**Consultation Response from KC,
Trees**

2023/90945 adj, 9, Hyrst Gardens, Batley, WF17 7EH

Erection of detached dwelling

Responding Ref: TPO 46/95

PLAN 2 OF 3	
Scale	1:250@ A3
Plan Title	Tree Impact Plan
Site	Off Track Rd, Batley
Date	7.2.23
tree@treeplan.co.uk

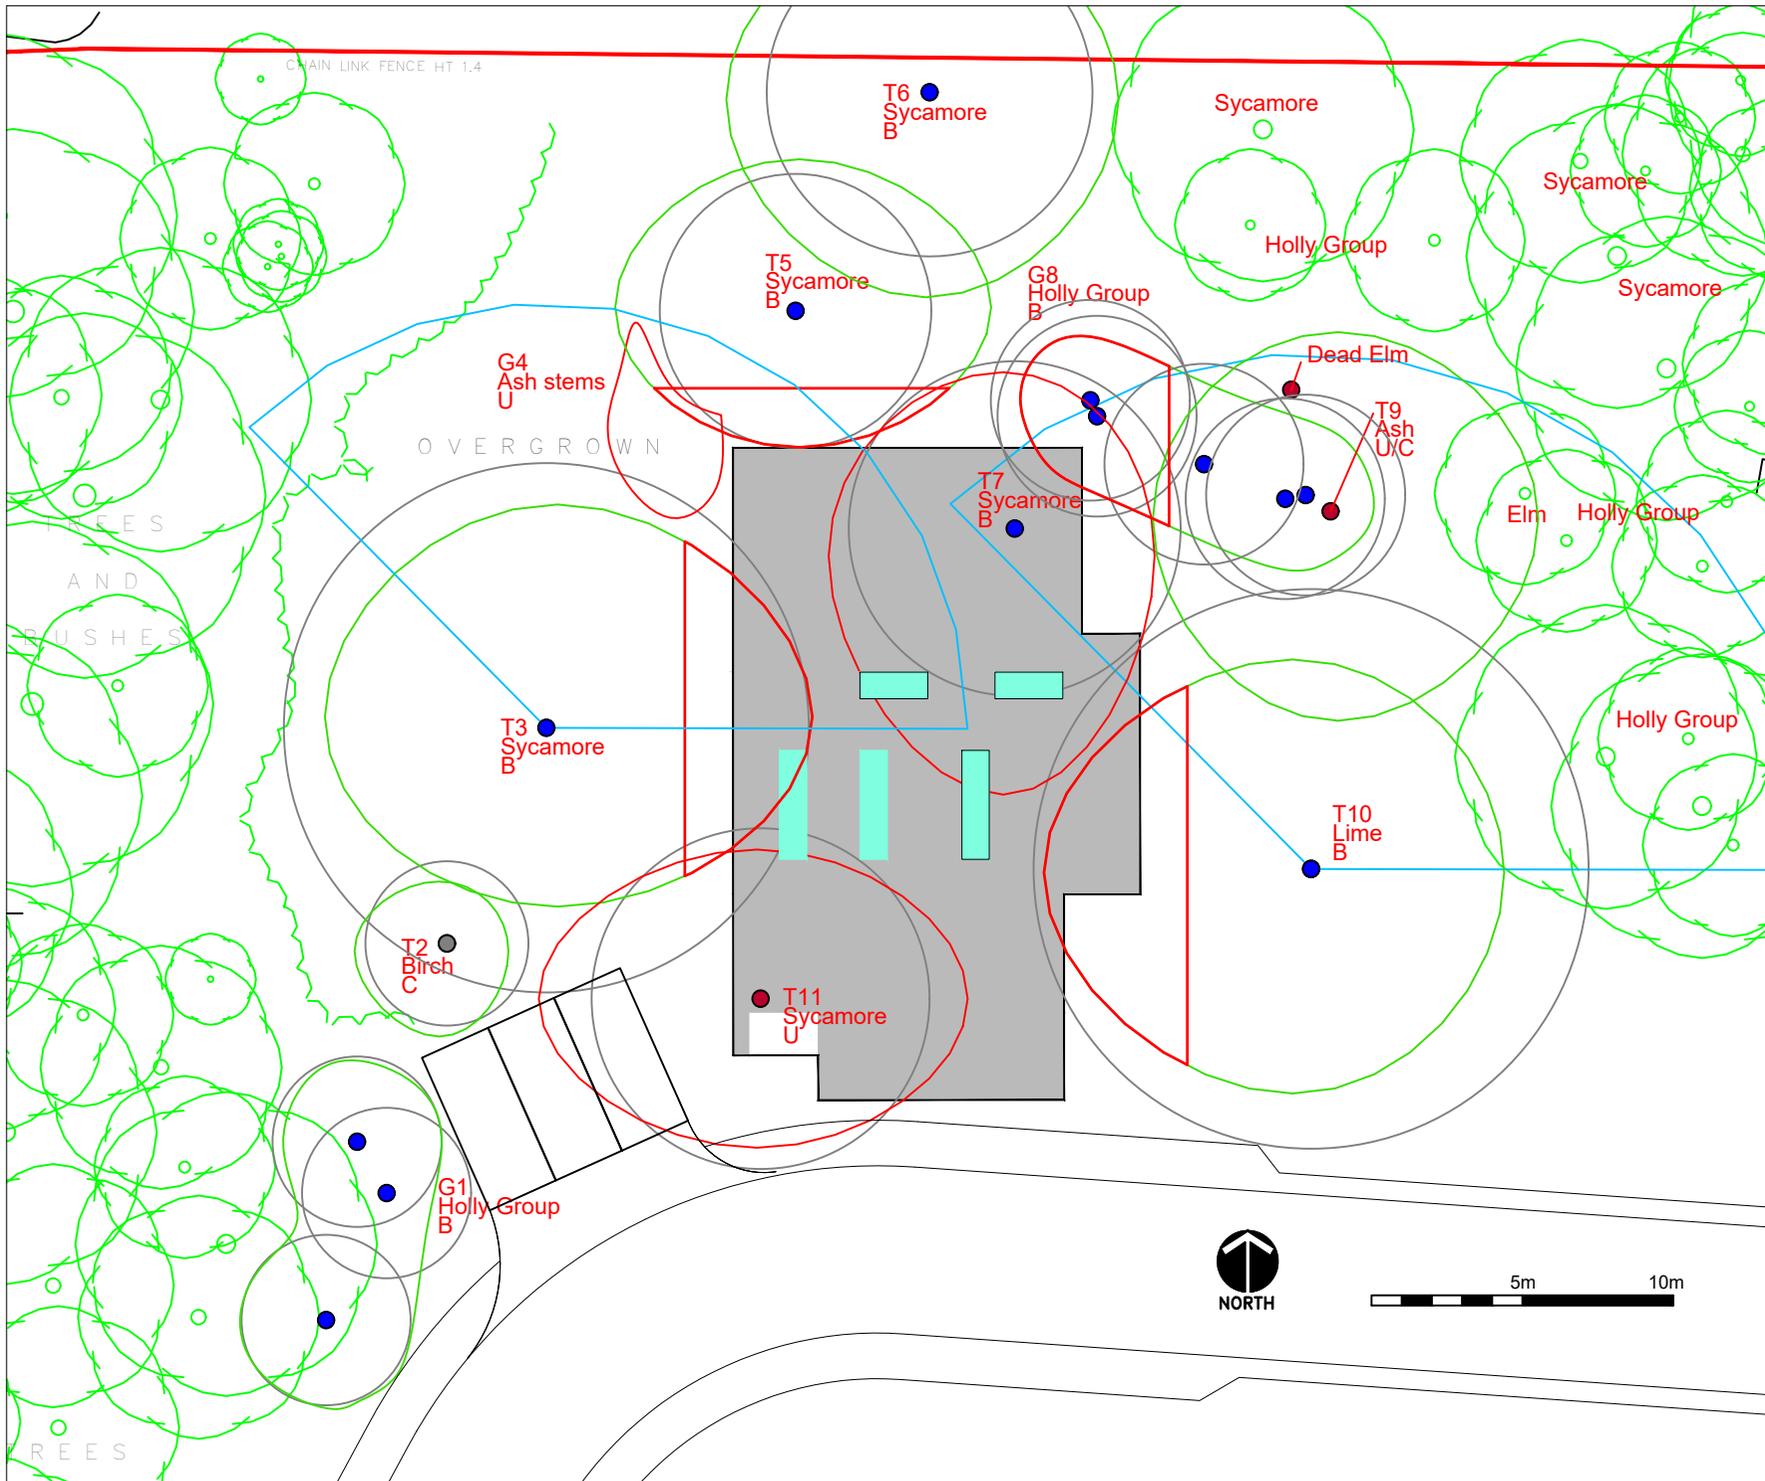
The proposals for a dwelling on this site would result in a significant impact on the important trees on this site. Tree report submitted suggests the loss of one tree and cutting back of others is acceptable however the loss of further trees on this site and the long term impact of the proposed dwelling so close to retained trees is contrary to Kirklees Local Plan policies LP24i and LP33.

The long term effects of the adjacent trees to the proposed dwelling from nuisance and shade impacts would likely result in a significant pressure to prune or fell the trees. For the above reasons the proposals cannot be supported.
